Response to Submissions Report – Newcastle Power Station, Tomago (SSI-9837)

Newcastle Power Station, Tomago (SSI-9837) – Response to submissions

Newcastle Power Station, Tomago (SSI-9837) – Response to submissions

**Figure 11 | Vegetation Zones and Distribution of Plant Community Types within the Development Footprint (Source: Amendment Report)**

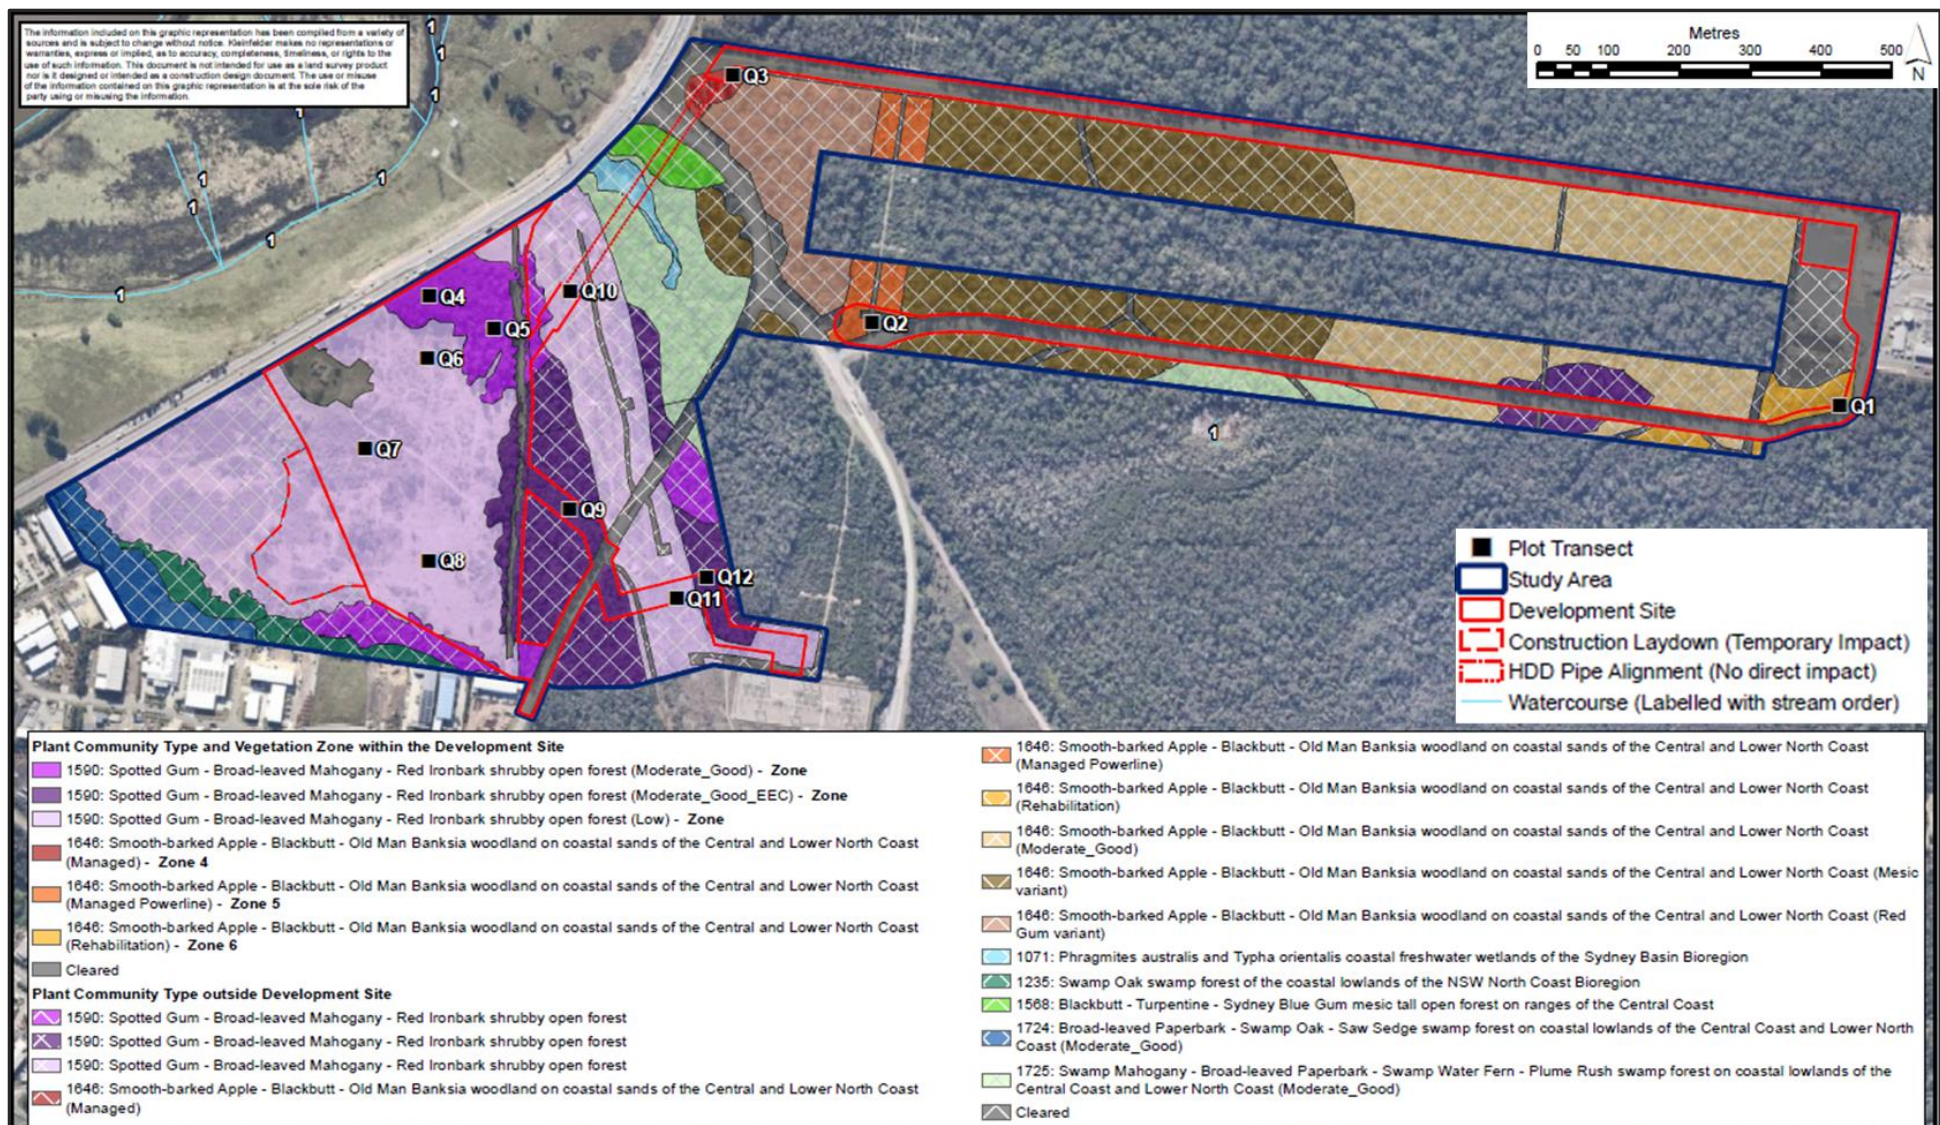
1. Vegetation zones 1 and 3 should be mapped as EEC

BCD's review of the Environmental Impact Statement (EIS) recommended that vegetation zones 1 and 3 within plant community type (PCT) 1590 be mapped as '*Lower Hunter Spotted Gum Ironbark Forest in the Sydney Basin and NSW North Coast Bioregions*' (LHSGIBF) endangered ecological community (EEC) consistent with the mapping of vegetation zone 2 (which is mapped as EEC). The revised BDAR (29 April 2020) does not provide sufficient justification for exclusion of vegetation zones 1 and 3 as EEC.

The revised BDAR relies on the lack of characteristic canopy species (e.g. *Eucalyptus fibrosa*) not being located in Zone 1 and the disturbed / degraded nature of Zone 3 to prevent these zones being mapped as the EEC.

Vegetation zones 1 and 3 are likely disturbed or local variants of PCT 1590, but they still fit within the broader description of the EEC, albeit lacking in some dominant taxa (as in Zone 1) or disturbed and undefined understorey with a +/- weedy ground layer (as in Zone 3). Vegetation zones 1 and 3 of PCT 1590 should be mapped as the EEC. This will likely lead to an increase in the ecosystem species credit yields for these two zones and affect the credit trading rules (i.e. reduce the number of PCTs they can trade with).

BCD recommends that vegetation zones 1 and 3 within PCT 1590 are mapped as Lower Hunter Spotted Gum – Ironbark Forest EEC consistent with mapping of vegetation zone 2 and the BAM calculator is re-run to determine the updated credit yield for these two zones and that the BDAR is amended.
